**Kevin Cox**  
**Crime Prevention Design Advisor**  
Thames Valley Police Headquarters South  
Oxford Road  
Kidlington  
Oxfordshire  
OX5 2NX

**REF: 22/02025/REM**

**Location: Bicester Gateway Business Park Wendlebury  
Road Chesterton**

30 August 2022

Site Layout Plan

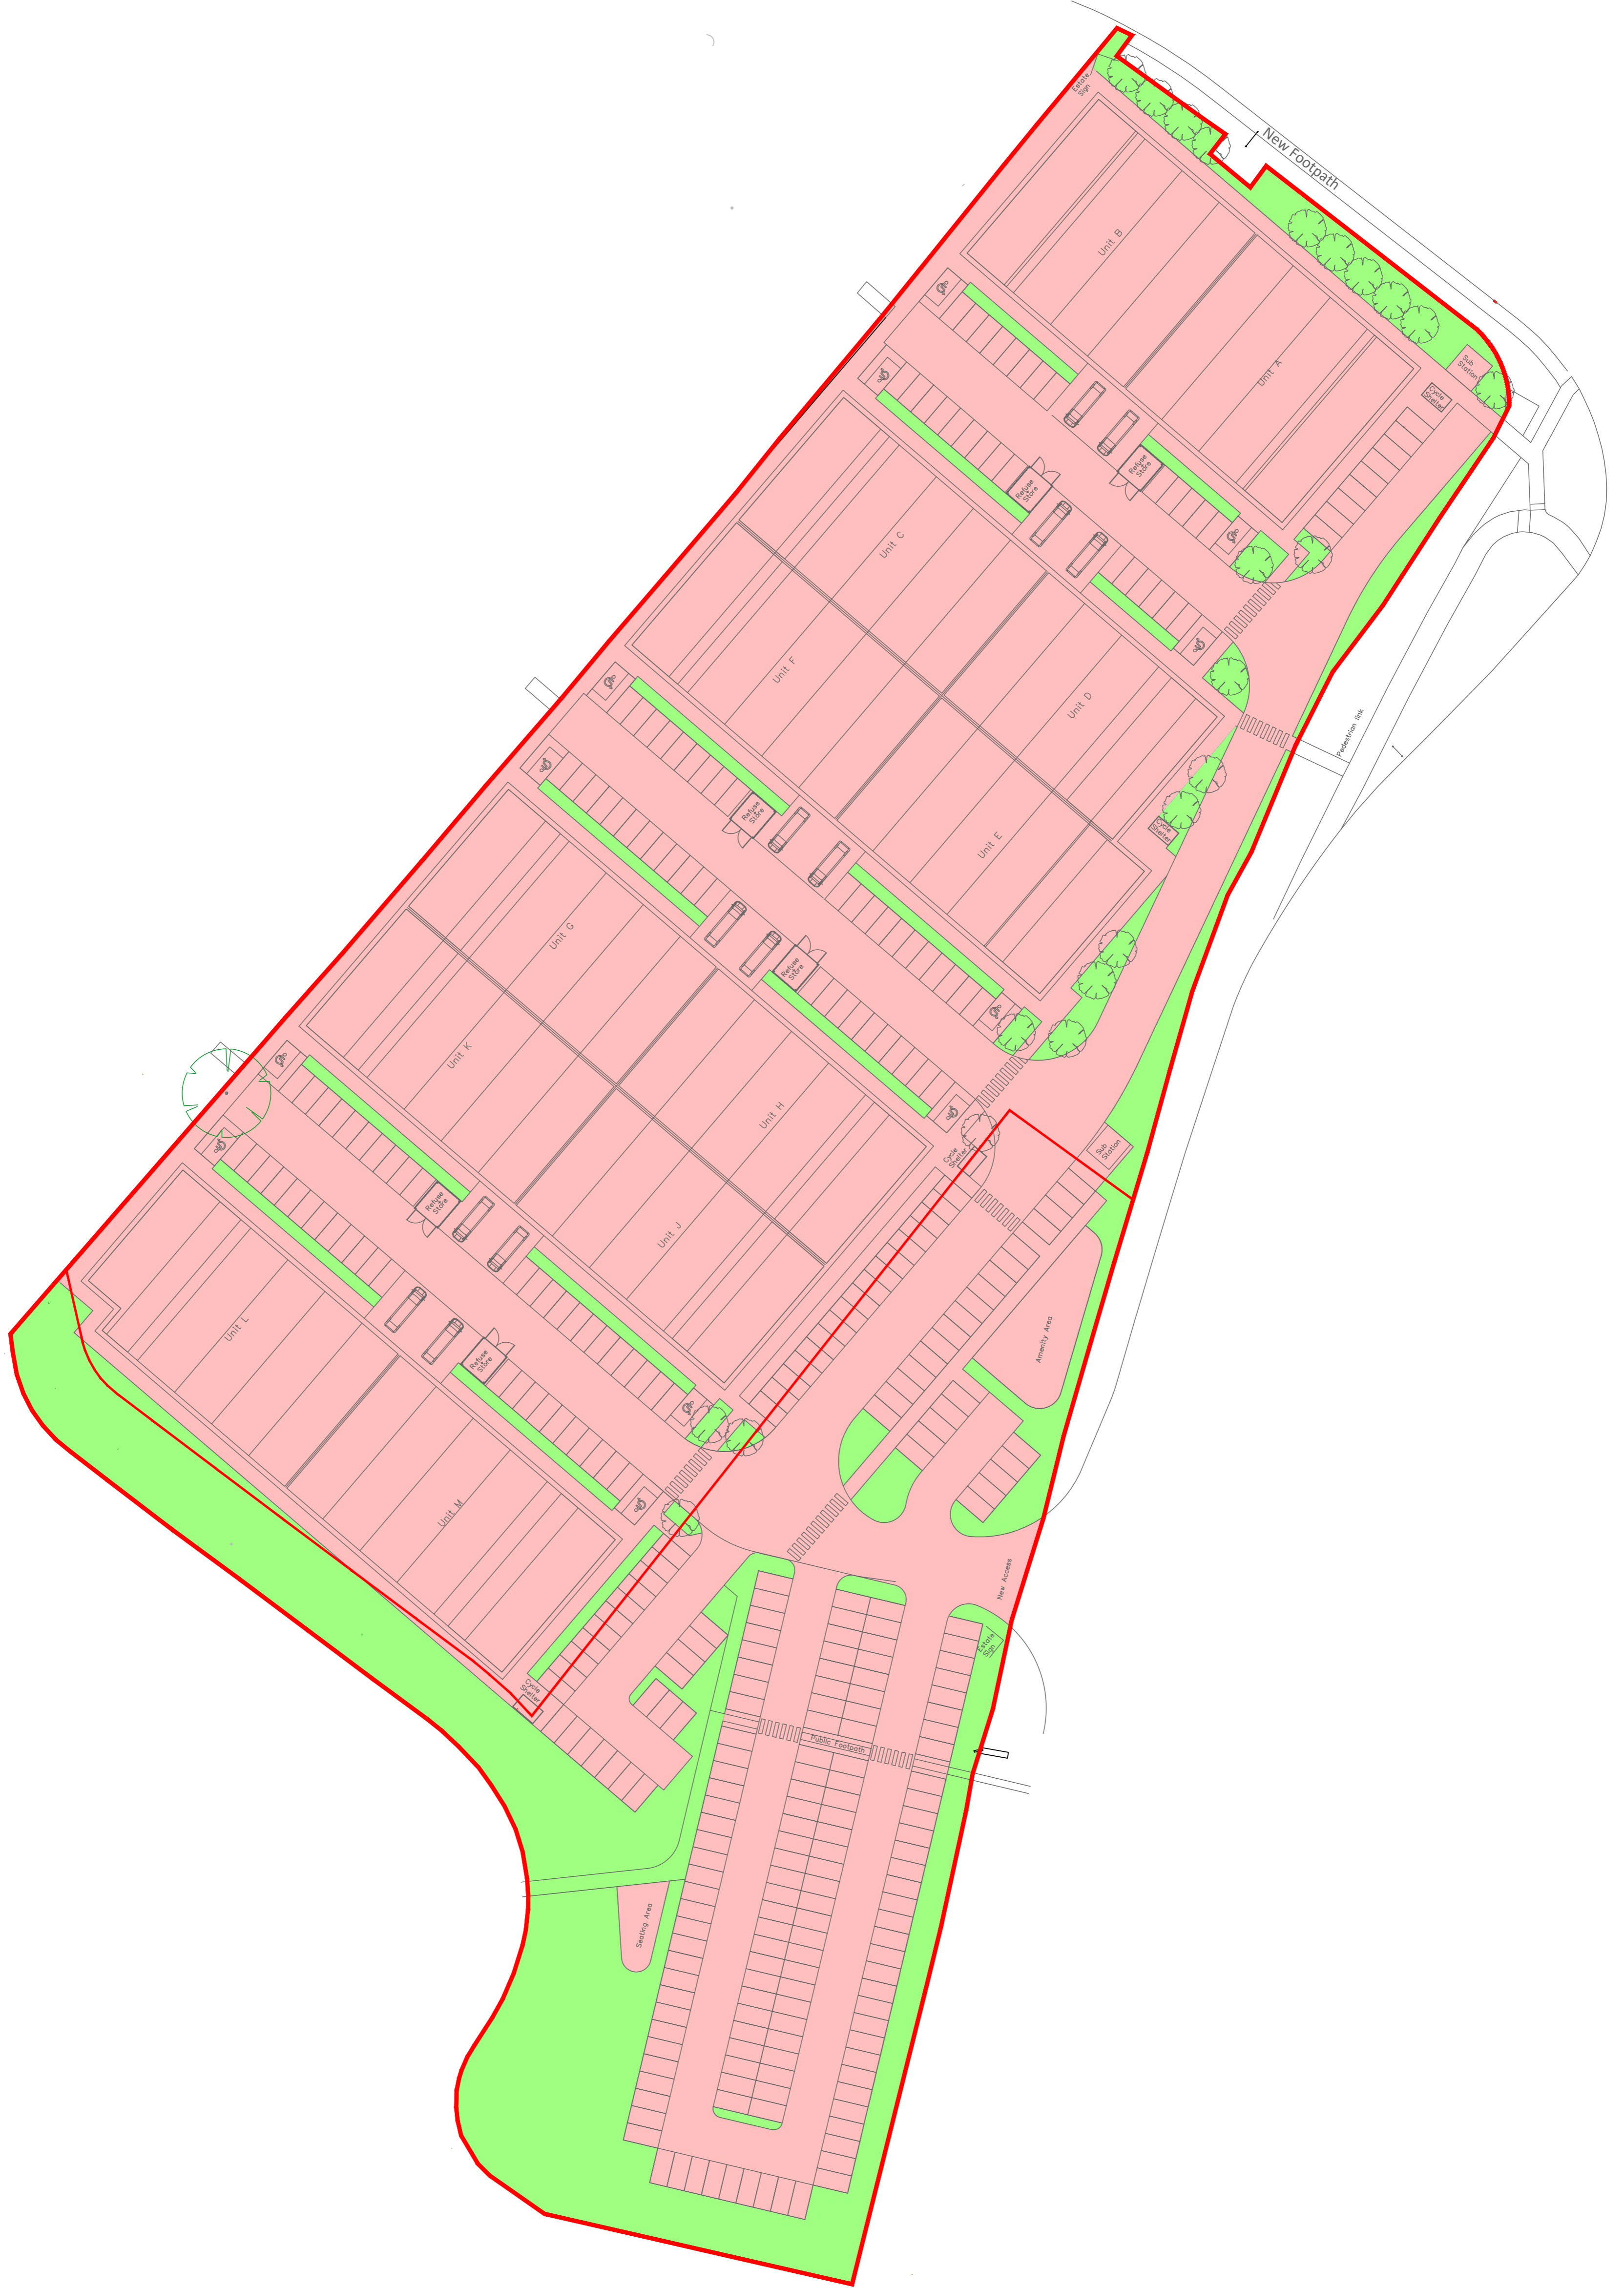
The entire development is vulnerable to crime and ASB, due to the site being excessively permeable throughout. Footpaths intersecting the site allow offenders legitimate access to all areas of the site, and prevents their identification and the ability to challenge those who should not be there. Whilst permeability is desirable in residential settings, I recommend in a commercial development such as this access should be permitted only to legitimate users of the development. Footpaths surrounding the site should be separated by suitable boundary treatments and landscaping to clearly demarcate the change in ownership from public to private space and prevent entry. Non-users of the development should not be encouraged to walk through the site, and it should have a clearly identifiable single point of entry and exit to reduce opportunities for unauthorised entry.

- The security of the car parks and vehicles within them is undermined by public footpaths intersecting

the site. This makes it impossible to identify and challenge offenders that are within what should be a secure parking area. I ask that any public footpaths are located outside of the car park, with sufficient boundaries and landscaping features to prevent unauthorised intrusion into the parking area. The parking area should be secure and accessible only to legitimate users of the car park.

- Surveillance opportunities to the south of the car parking area are reduced as parking is located away from buildings, only overlooked by a parking area of adjacent development. I recommend parking is located where it is well overlooked by the buildings that it serves, and additional protection in the form of formal surveillance (CCTV) should also be provided.
- The parking area is fully accessible and open, leaving it at risk of crime, ASB and illegal encampments, particularly late at night or during periods of low occupation. I recommend all private car parking areas are protected with boundary treatments, landscaping and barriers to prevent unauthorised access. Height restriction barriers should also be provided for areas away from buildings that are intended for car parking only.

It is unclear from the masterplan what surveillance will be afforded to cycle parking, particularly without any form of layout indicated within the units. Some stands are located in areas where they are potentially going to be vulnerable due to a lack of surveillance. I ask that all cycle stands are relocated so that they are adjacent to the entrances to units, where they will be well overlooked by the entrance and surveillance from people coming and going from the units. Formal surveillance (CCTV) should also cover all cycle storage areas.

Bin stores are also potentially vulnerable to crime and ASB, with entrances not well overlooked by surveillance from the units they serve. I recommend bin stores are robustly secured with doors that meet the certification of LPS 1175 S7 SR2 or equivalent.
